## Appeal Decision

**Appeal Ref: APP/Z4718/W/24/3347125**

**Sada E Madina, 38a-40 Thorne Road, Thornton Lodge, Huddersfield HD1 3JJ**

- The appeal is made under section 78 of the Town and Country Planning Act 1990 (as amended) against a refusal to grant planning permission.
  - The appeal is made by Mr Usaamah Mansur (Al Ittihaf) against the decision of Kirklees Council.
  - The application Ref is 2024/62/90232/W.
  - The development proposed is the erection of side extension and rear dormer.
-

Proposed Floor Plan

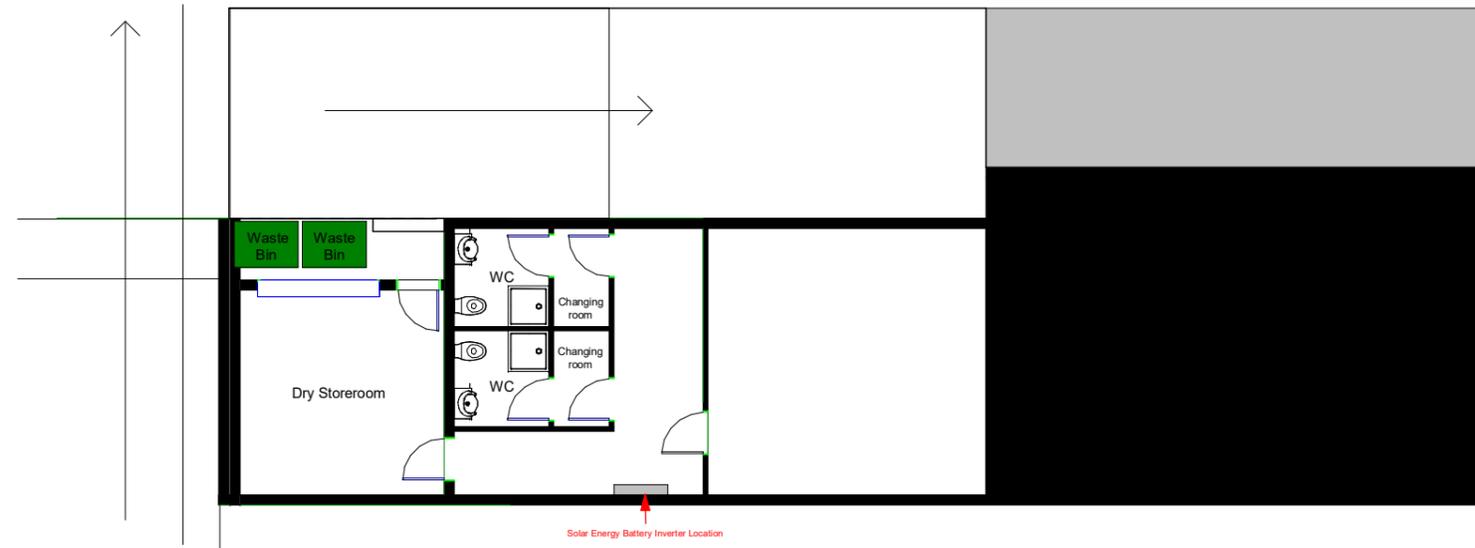
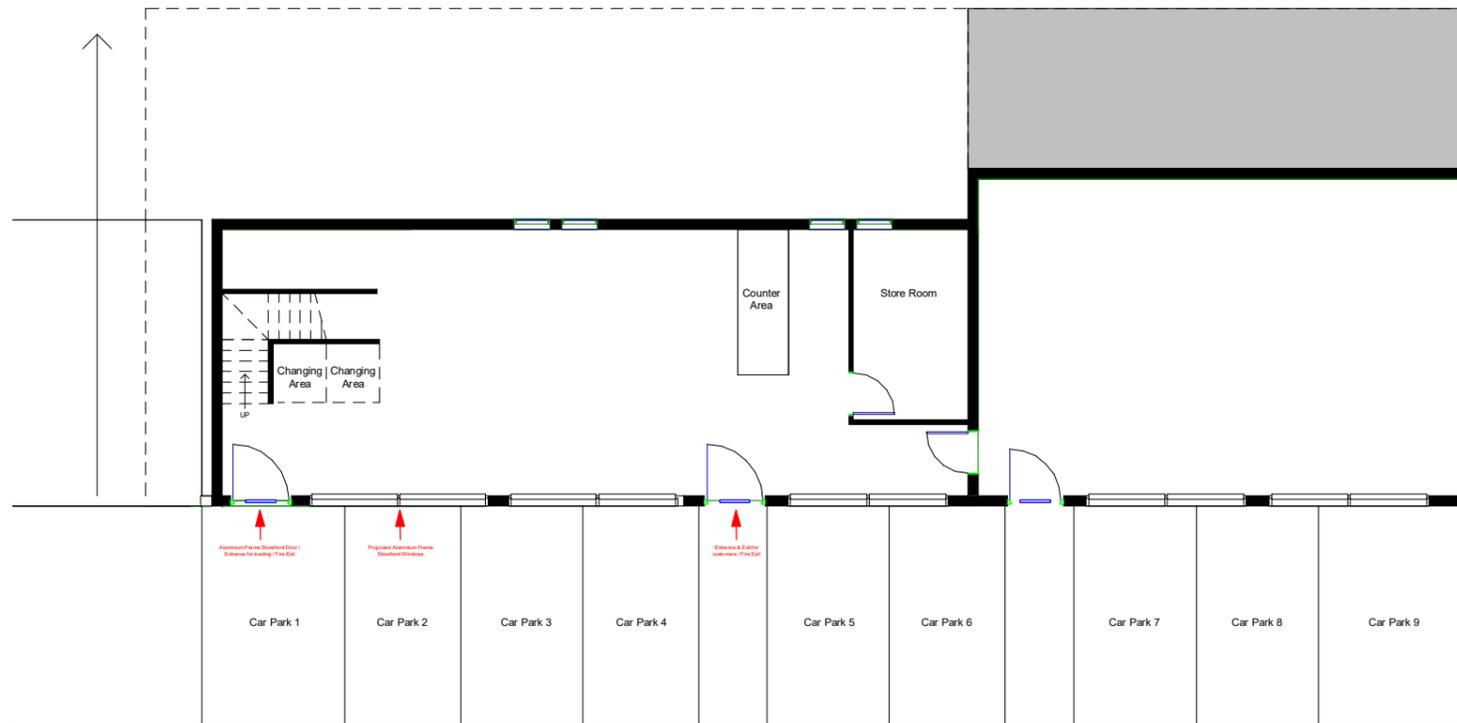
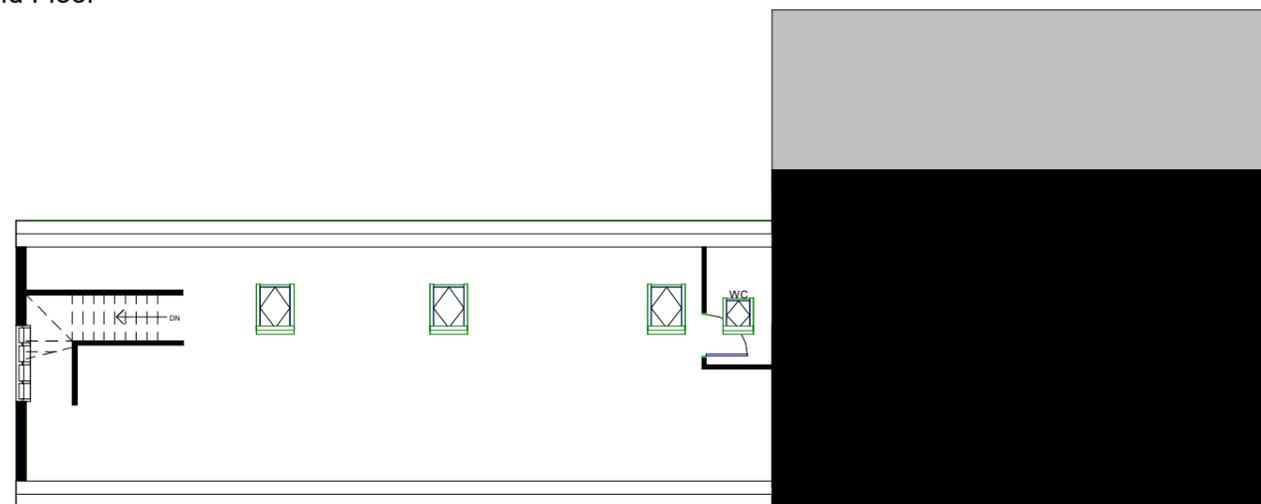
5. The proposed side extension would continue the ridge line of the nearest part of the existing building, with no setbacks from the front or rear elevations. It would not appear subservient to the existing building, but in an area the contains long terraced rows, including directly opposite the appeal site on Thorne Road, I do not consider this lack of subservience to be harmful in this instance. Similarly, the extended building would project past the building line of the nearest properties that are situated broadly to the north of the site and be set close to the boundary wall. However, given the curvature of Moorbottom Road and some properties along it being set at differing distances from the road, the size and scale of the side extension would not detract from the host building and nor would it appear cramped in an area characterised by tight knit terraced rows that provide enclosure to the streetscene.

### Proposed Elevations

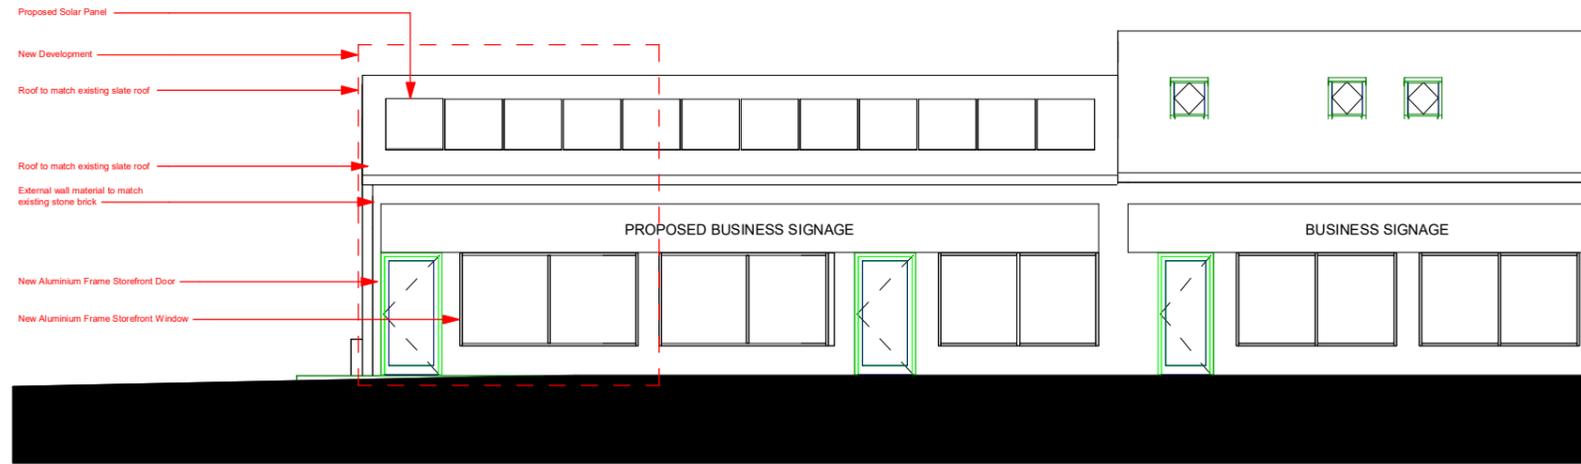
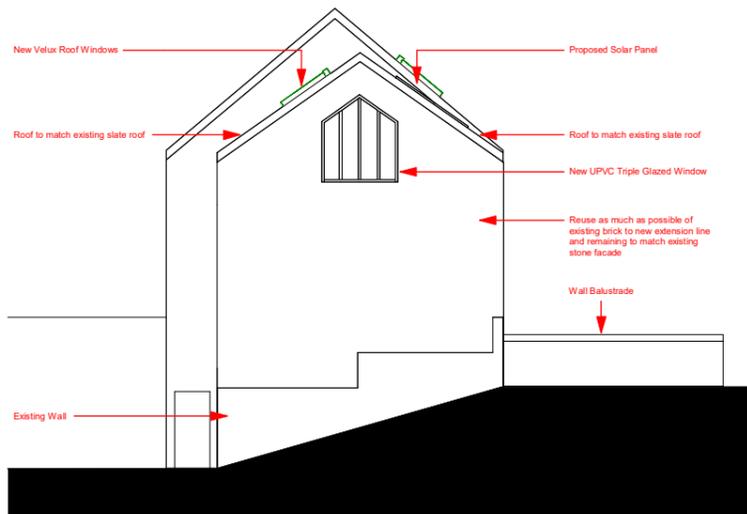
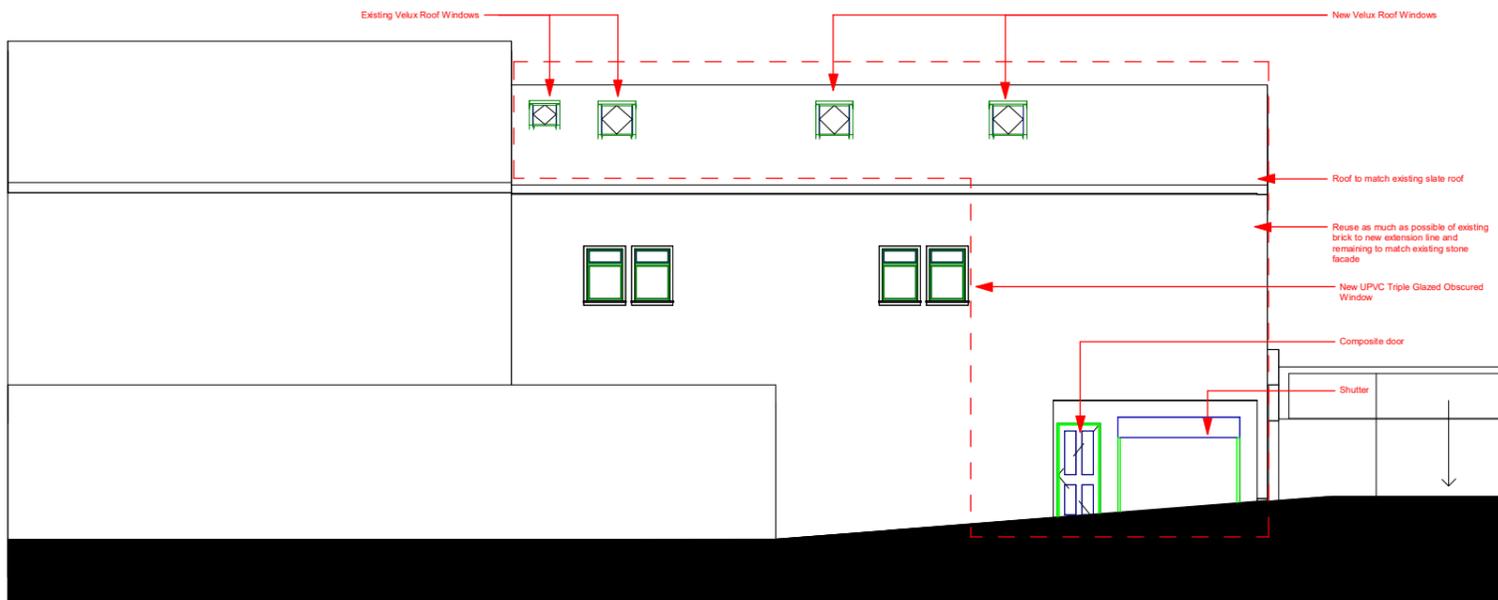
6. A rear dormer is also proposed, which would extend over part of the existing building and the proposed side extension. With a width of over 10m, it would be of a considerable size, and it would therefore appear as an incongruous addition to the building. Its flat roof form would also be at odds with the predominantly pitched roof form of the surrounding properties. Although the dormer would be concealed from views along parts of Moorbottom Road, the corner location of the appeal site would mean that the dormer would be seen in close range views from this road where it would appear visually harmful.

7. Solar panels are also proposed which would cover an extensive area of the front roofslope of the existing building and the proposed side extension. Whilst they would be clearly visible due to their intended front siting, and are not a common feature in the area, they would nevertheless have a slim profile and be arranged to follow the roof plane. As such, and given the dark appearance of the proposed panels, I do not consider the solar panels would be unsympathetic additions.
